City of Albuquerque Stormwater Construction Site Inspection Report

ESC File No.	C17E119	Project Name:	Horizon Village		
NPDES Id. No.	NMR10023F	Location:	8814 Horizon Blvd.		
2/28/2022	Owner			Contractor	
Operator	Stillbrooke Homes				
Contact name & title	Chris Kelsey				
e-mail	ckelsey@stillbrooke.com				
Contact Phone #	858-1800				
COA Inspector	Doug Hughes		Start/End Time:	11:30 AM	
Construction Phase:	idle				
Type of Inspection:		Storm Event	Past Storm Event >0.25"	311/Complaint	Follow Up
Weather at time of inspection?		clear		Temperature: ~	50
Estimated date of last storm 0.25" or greater		1/1/2022

Concrete Washout Area

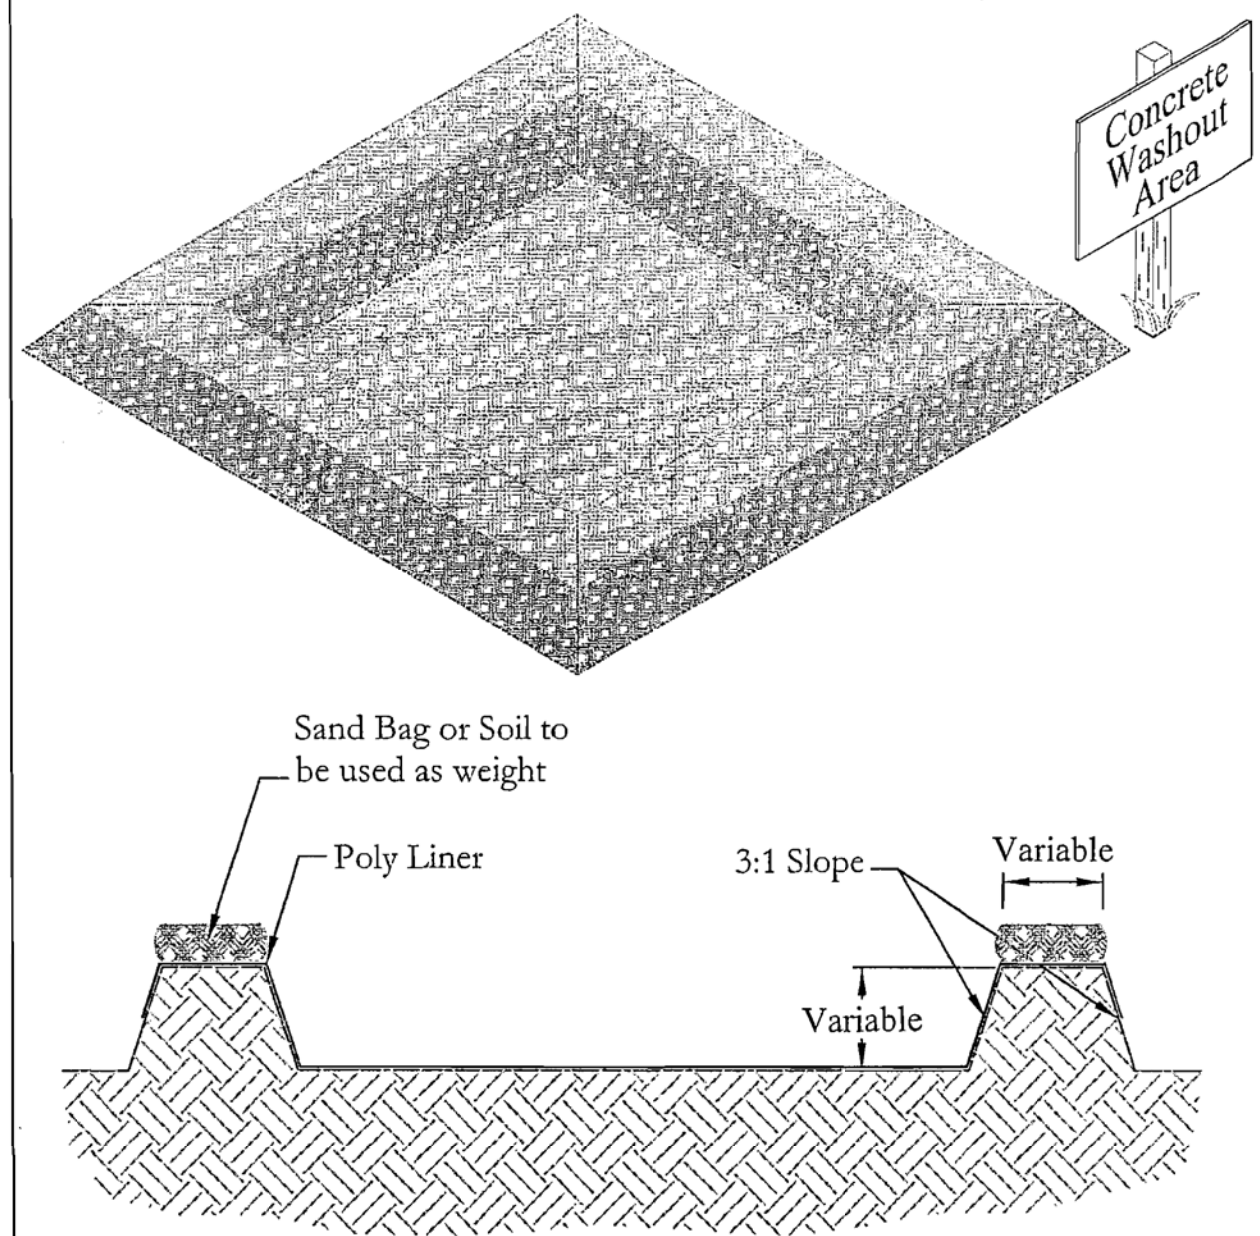
Item Number	Deficiency/ Corrective Action				
1	Washout still on the ground. Pick up and remove with waste. It doesn't look like a lot of new washout, and some washout went into the new containers, but the previous washout hasn't been removed.				
2					
3	SWPPP was not available onsite. The sign still says to call Inspections Plus for SWPPP information. But they don't have it. Up-date the SWPPP and make it available onsite, and correct the sign.				
4
